PAVEMENT DESIGN STUDY  
GRANDWOOD RANCH  
FAIRPLAY DRIVE AND HIGBY ROAD  
MONUMENT, COLORADO  
80132

PROJECT NUMBER 21-1238  
JULY 26, 2021

Please add "PCD  
File No.  
SF-20-026".

GRANDWOOD RANCH	
EL PASO COUNTY - SF 2026 ROAD AND STORM PLANS	
ROADWAY GENERAL NOTES	
DESIGNED BY: CAP DRAWN BY: NMS CHECKED BY: NMS	SCALE: HORIZ. N/A VERT. N/A DATE ISSUED: FEBRUARY, 2021 SHEET 4 OF 40 DRAWING No. TY01

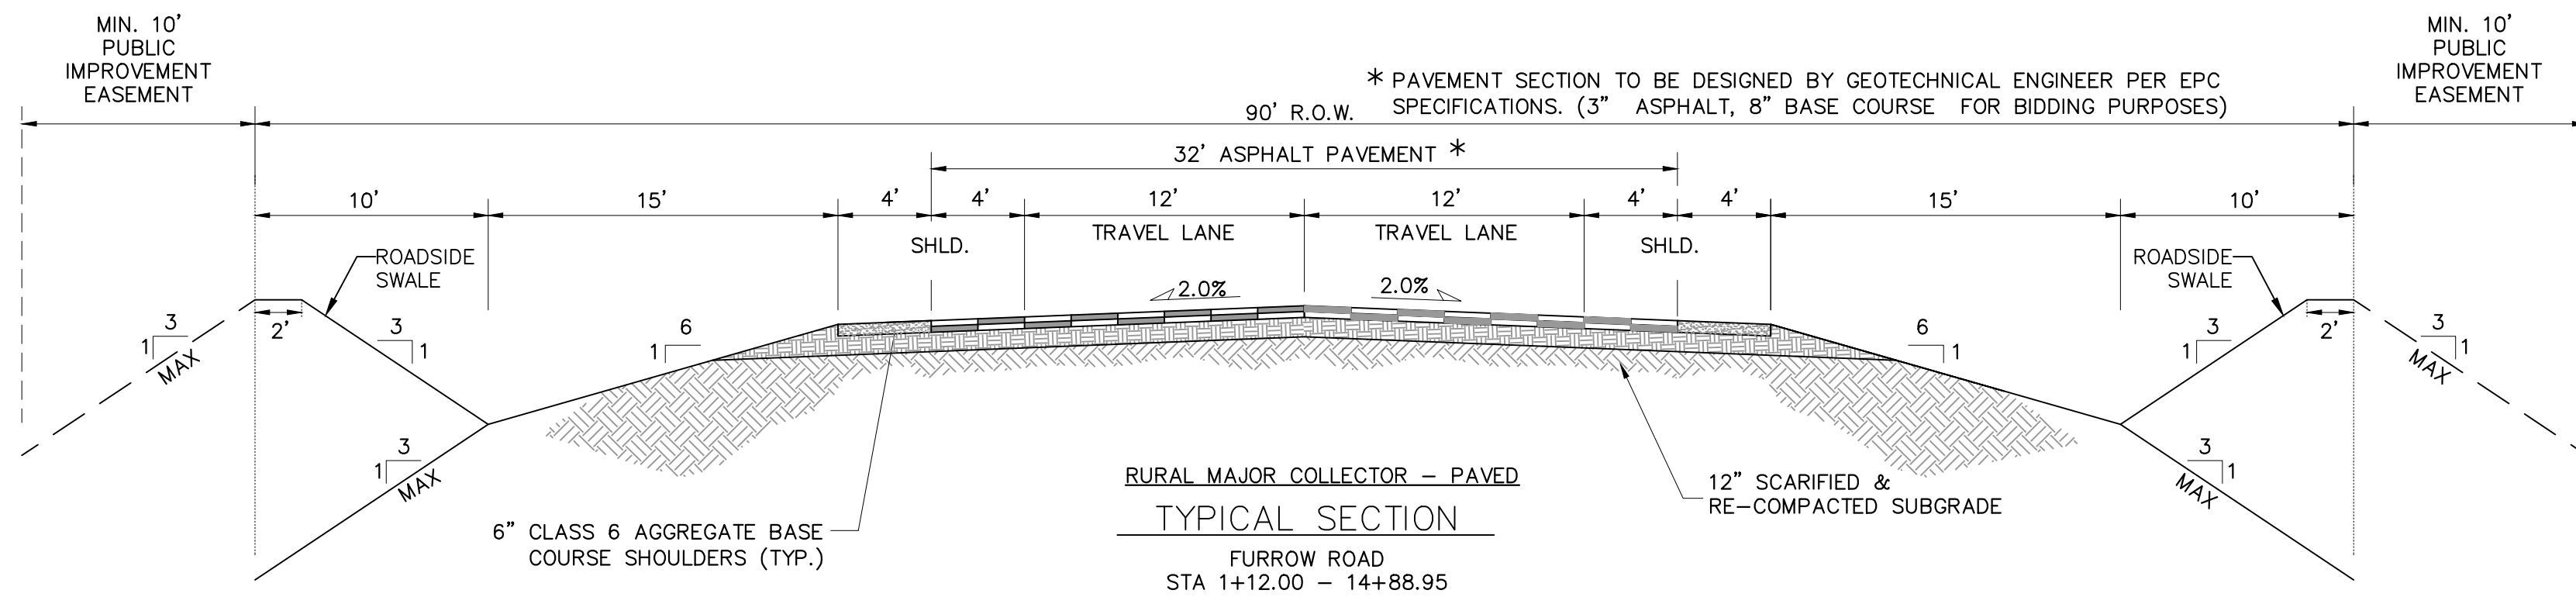
Per Grandwood Ranch TIS (PCD File Nos. P191 and SP195) Furrow Rd is a two lane rural major collector. Please update to match report.
